# Peak Truss Builders, LLC

## Comments and Clarifications

Job #:	Description:	Notes:
<b>Q-2001892</b>	<b>Weaver Smith Residence V2</b>	Floor Trusses I-Joists LVLs
Customer:	Contact:	S&S Contracting
<b>JE Womble and Sons</b>	<b>Steve Butts 919-669-2998</b>	
Address:	Site Address:	
<b>805 W Front St PO Box 580 Lillington NC 27546</b>	<b>503 Ballard Rd Fuquay Varina NC</b>	
<b>O: (910) 893-4347 Keith Bullock (919) 427-4628</b>

Weaver-Smith Resd  
I-Joists  
11-7/8" Depth  
19.2" OC

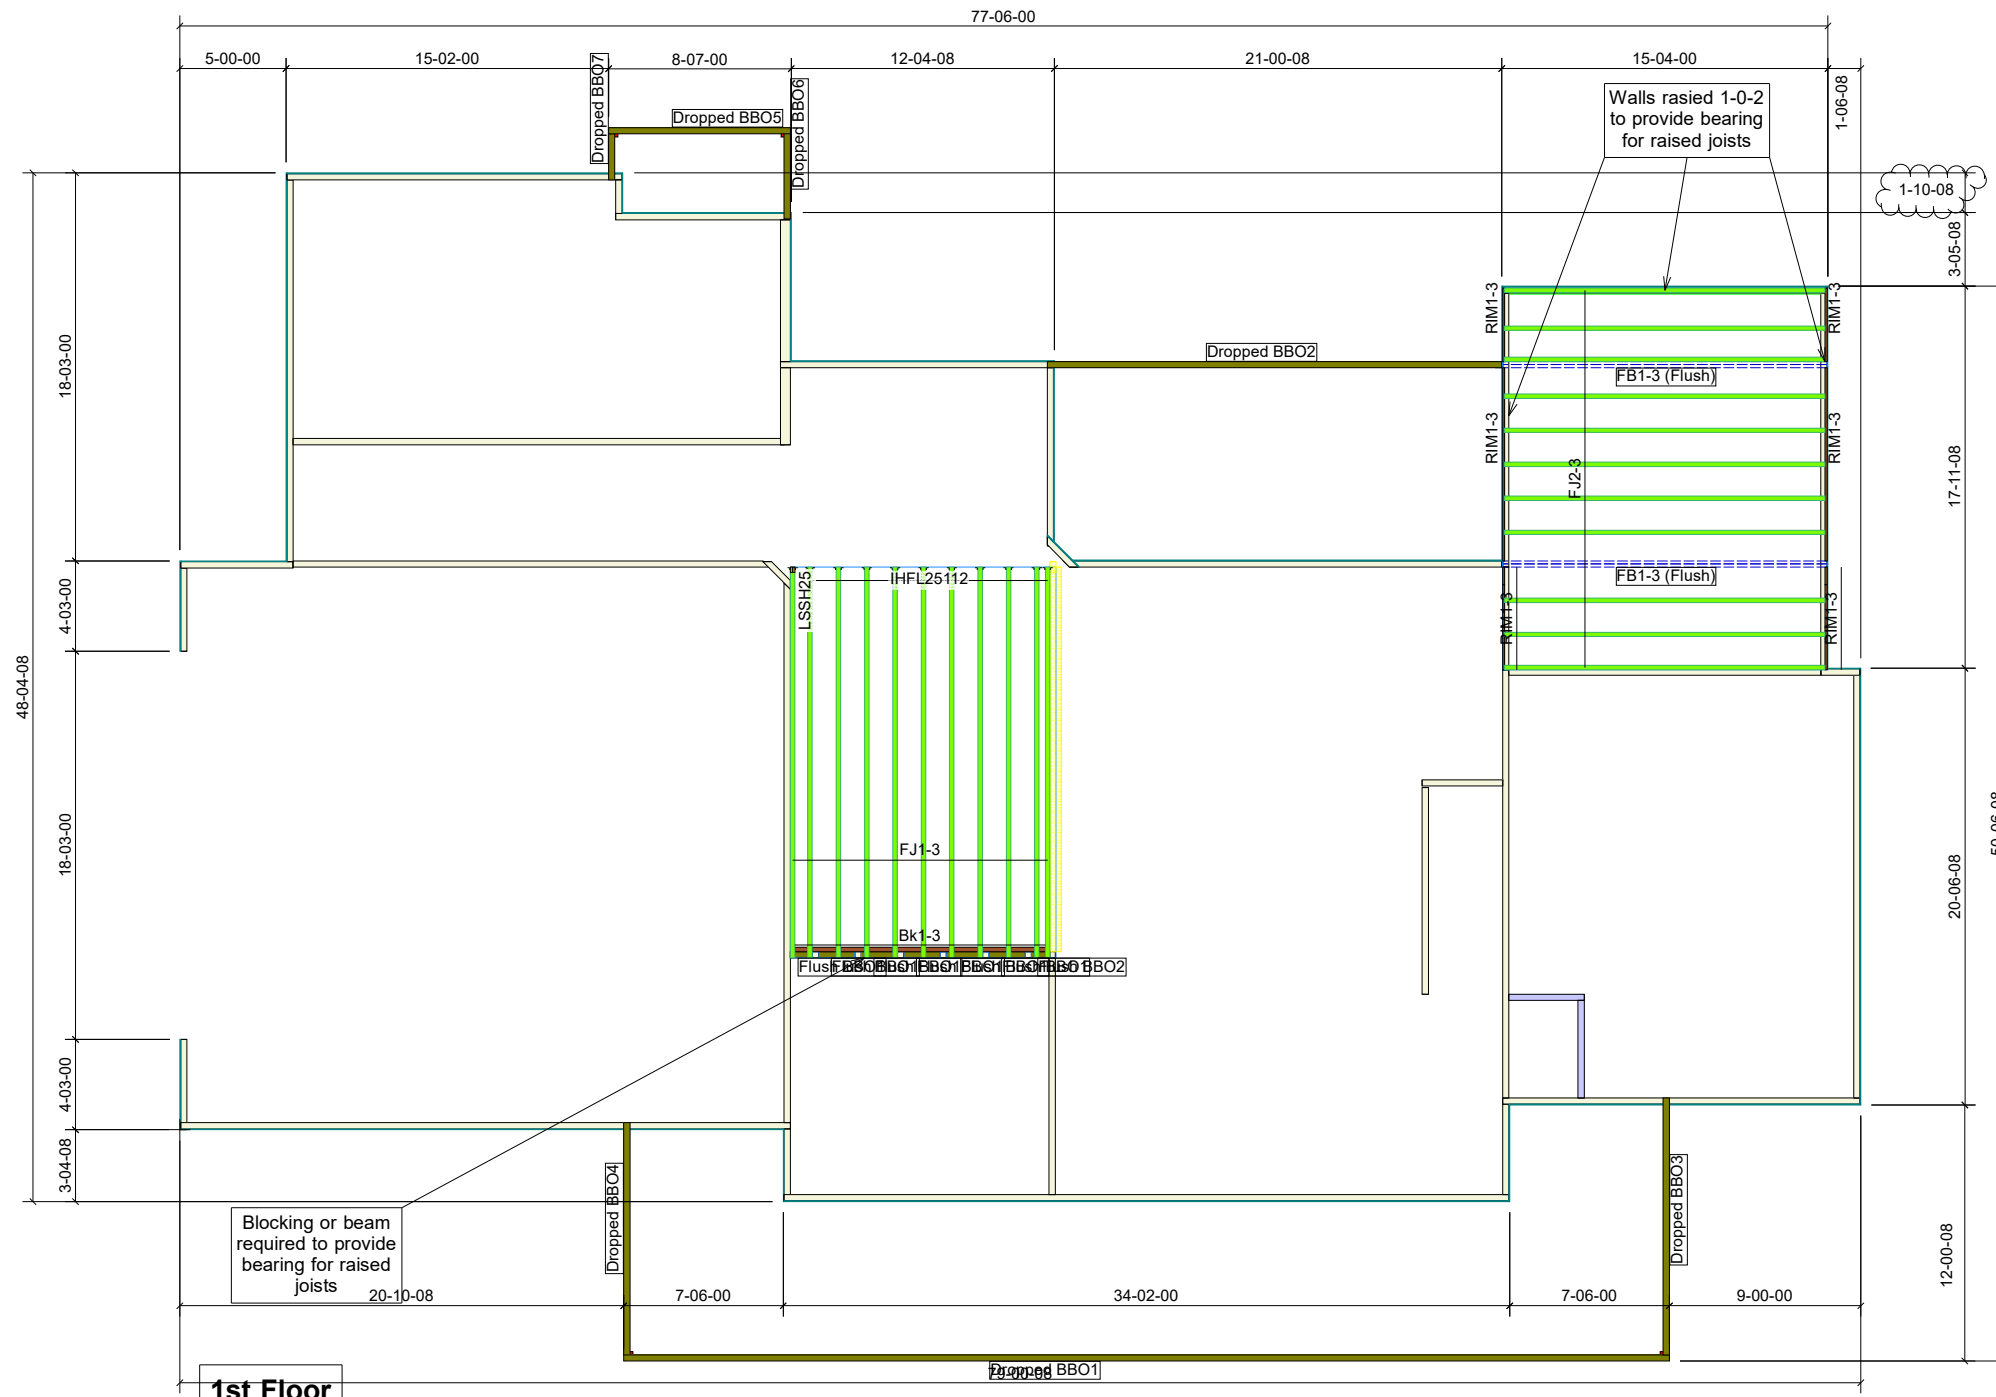
4. Plan dimensions have some conflicts. Please verify all bubbled dimensions.
5. I-Joists raised to match 24" floor trusses will require raised wall, beam, or blocking by others for bearing.
